**RE: Chama Street Affordable Cottage Development  
Grading and Drainage Plan  
Engineer's Stamp Date: 10/24/2025  
Hydrology File: K19D157  
Case # HYDR-2025-00384**

Based upon the information provided in your submittal received 10/24/2025, the Grading & Drainage Plan is **not** approved for Grading Permit, Building Permit, SO19 Permit or WO. The following comments need to be addressed for approval of the above referenced project:

GRADING PLAN

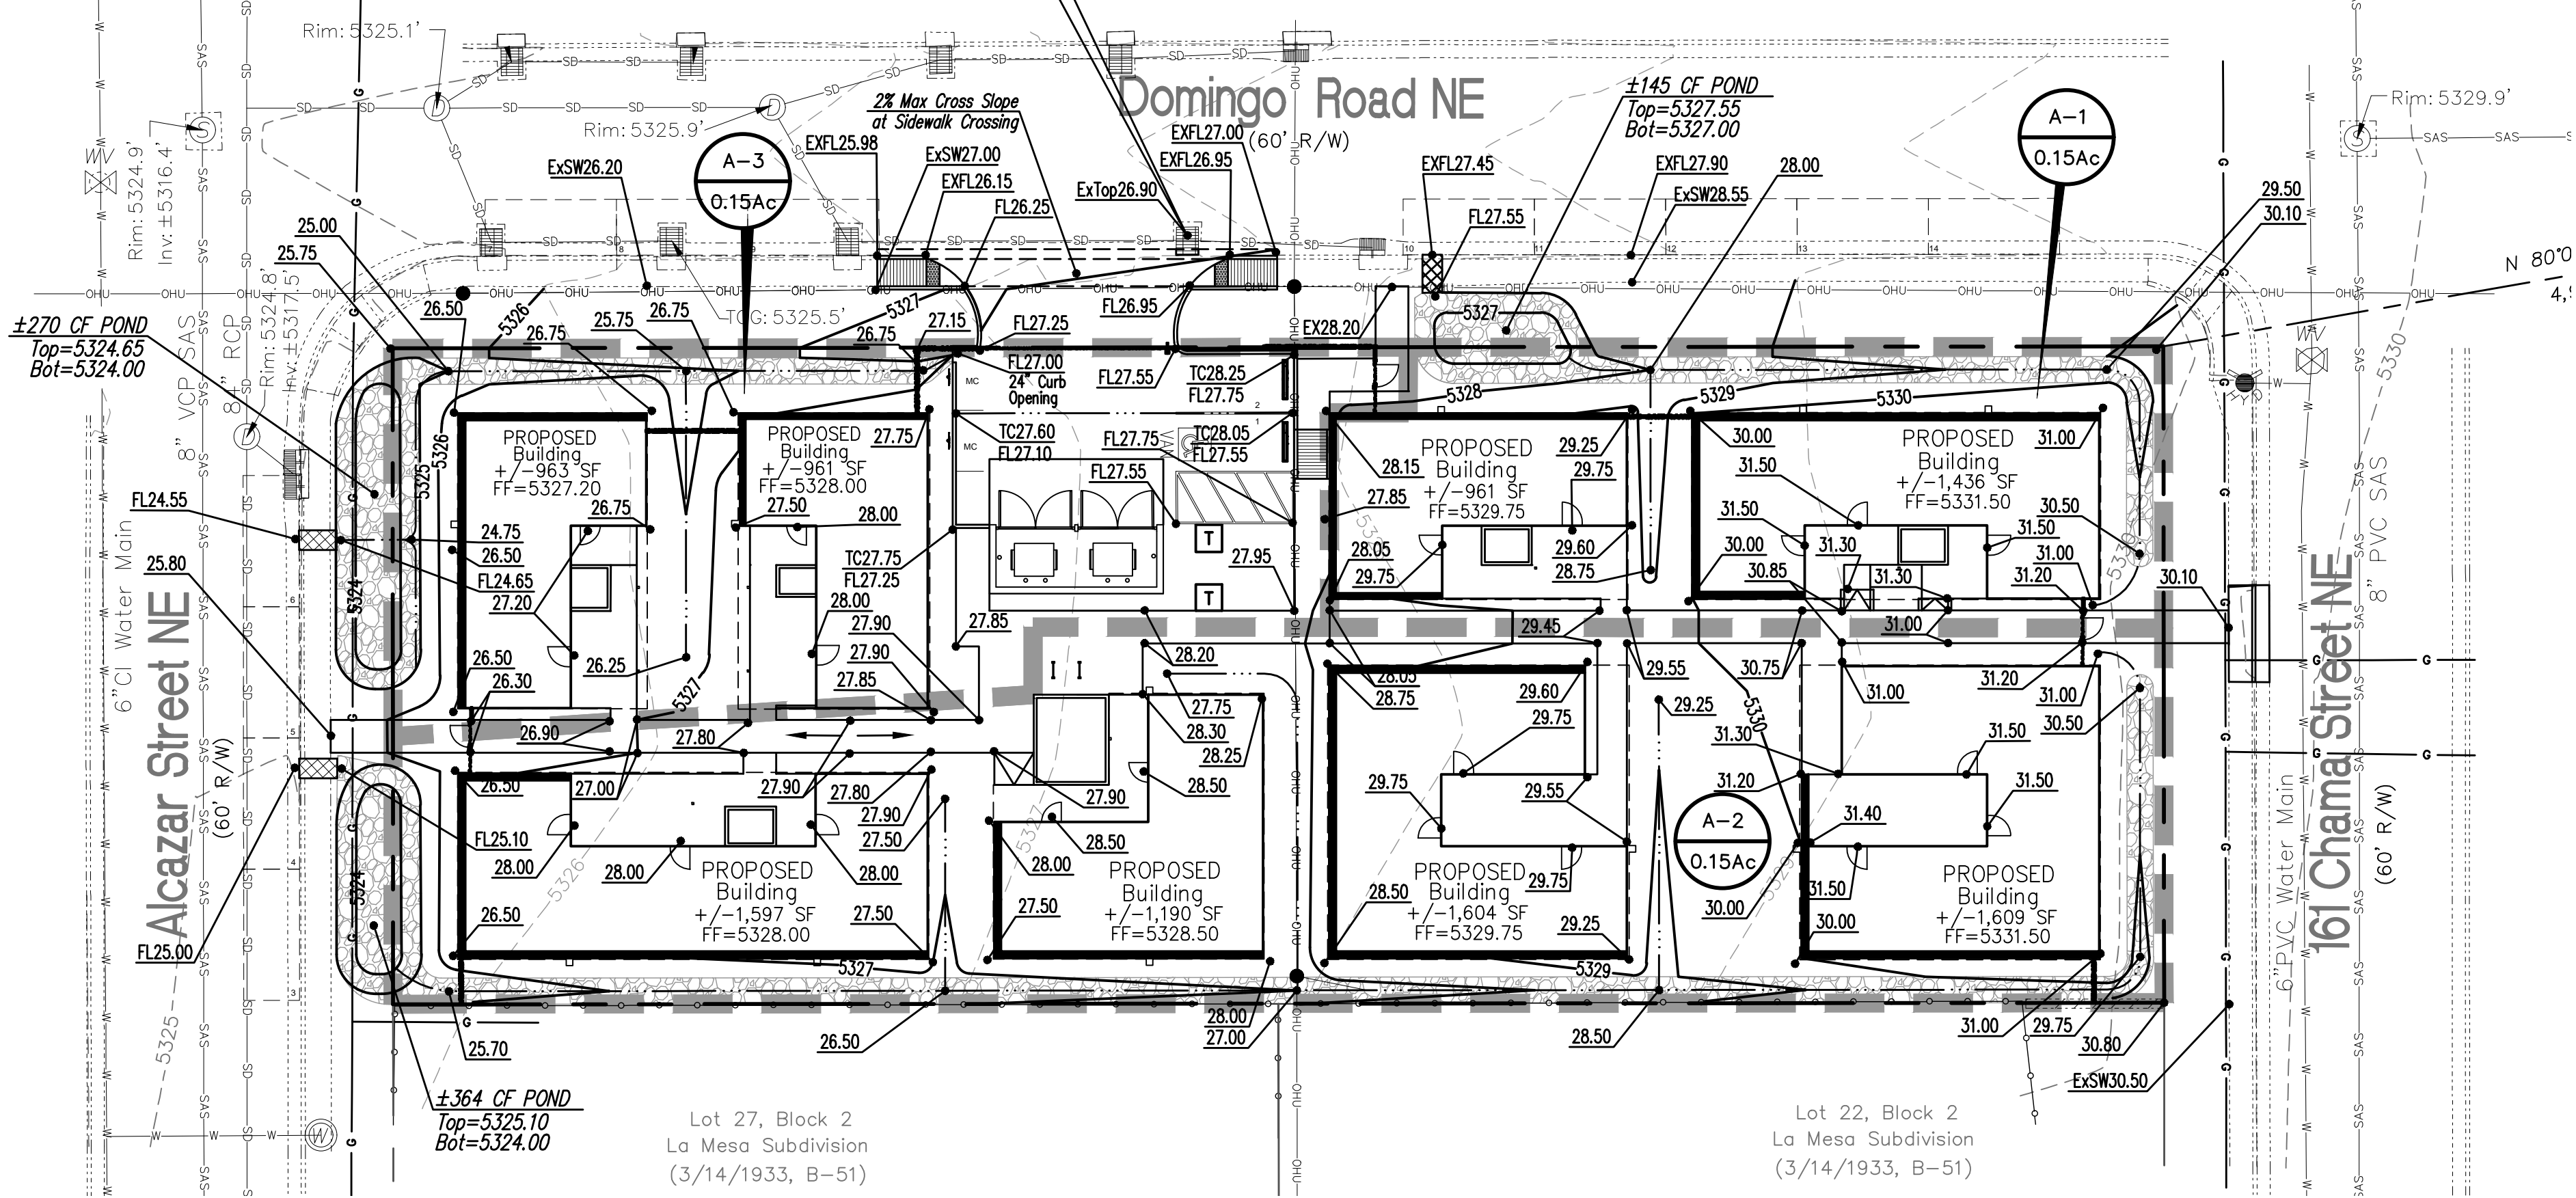
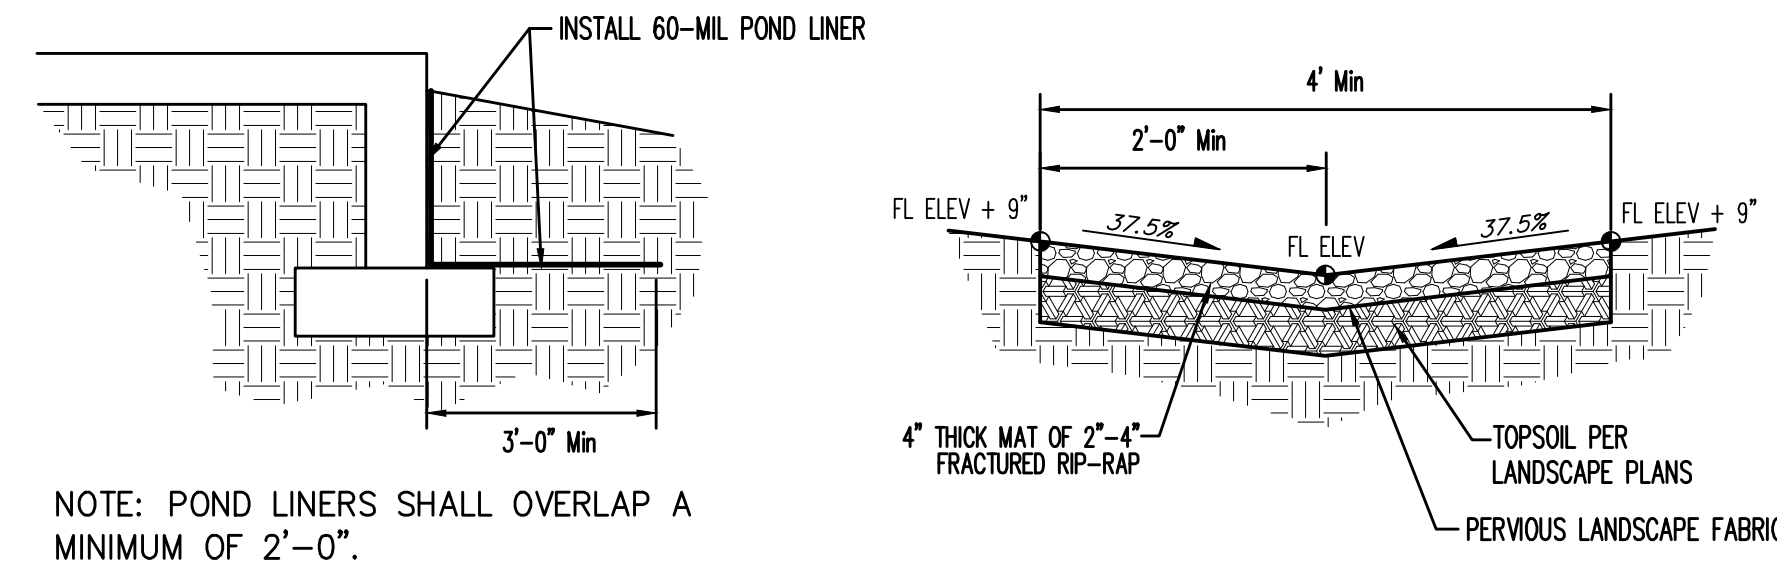
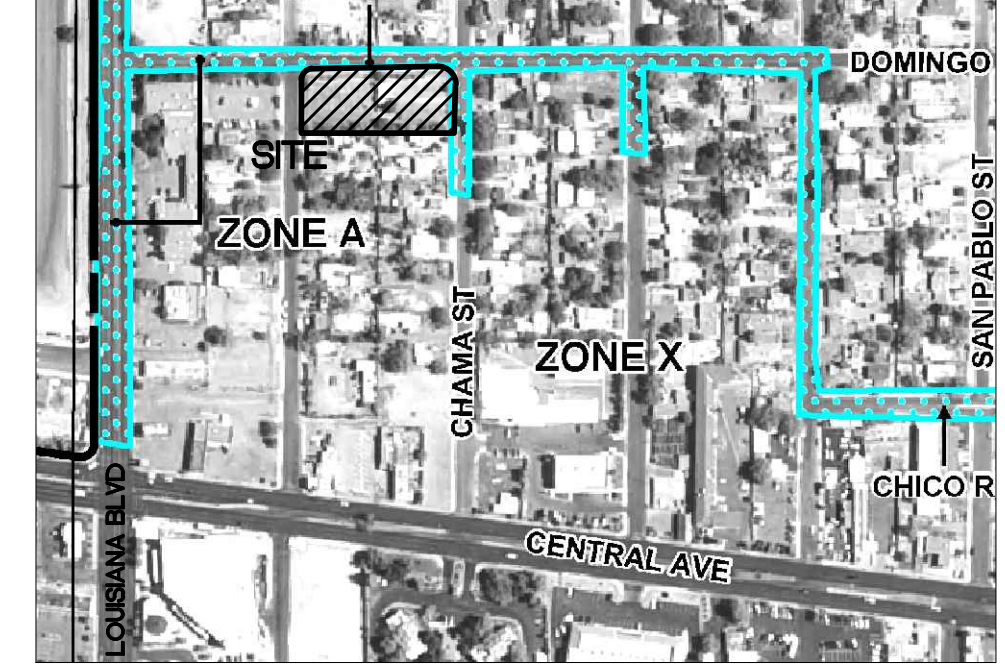
1. Per Part 6-6(D) of the DPM: For development adjacent to or in an unnumbered A Zone, the base flood elevation (BFE) will be determined by best available data. If no data are available, the BFE is considered to be 2 feet above the highest adjacent grade. Please show the SFHA Zone A on the plan and state the determined BFE that will be used for the SFHA adjacent to the development.

2. Ensure that the lowest finished floor elevations are designed to be 1 foot above the BFE.
3. Add a note to the plans that due to the adjacent SFHA Zone A, a Pad Certification is required for Hydrology verification prior to approval for Building Permit. The required Engineer's Certifications should also be noted on the Infrastructure List.

4. Drainage Narrative – Please add mention of the adjacent SFHA Zone A along the east and north perimeter of the site.
5. An SO-19 Permit will be required and should be included on the request. Please include the [standard SO-19](#) notes on the grading plan.

6. Please call out the sidewalk culverts on the plan and reference City of Albuquerque standard detail No. 2236 – Sidewalk Culvert with Steel Plate Top at the sidewalk culvert.

7. Provide management onsite for the Stormwater Quality Volume (SWQV) in accordance with the new drainage ordinance, § 14-5-2-6 (H). **Please show the top and bottom of the ponds along with the volume for each pond.** The onsite drainage should be directed to these ponds prior to being collected in a private unground drainage system. Please follow the DPM Article 6-12 Stormwater Quality and Low-Impact Development for the sizing calculations. To calculate the required SWQV, multiply the impervious area draining to the BMP by 0.42 inches for new development sites and 0.26 inches for redevelopment sites. The calculations of both the required and the provided volume of

each BMP must be shown on the Grading and Drainage Plan. **Each BMP should be labeled on the Grading and Drainage Plan with the required SWQV and associated water surface elevation and the 100-year water surface elevation. Landscaping of surface BMPs is also required to be noted on the Grading and Drainage Plan.**
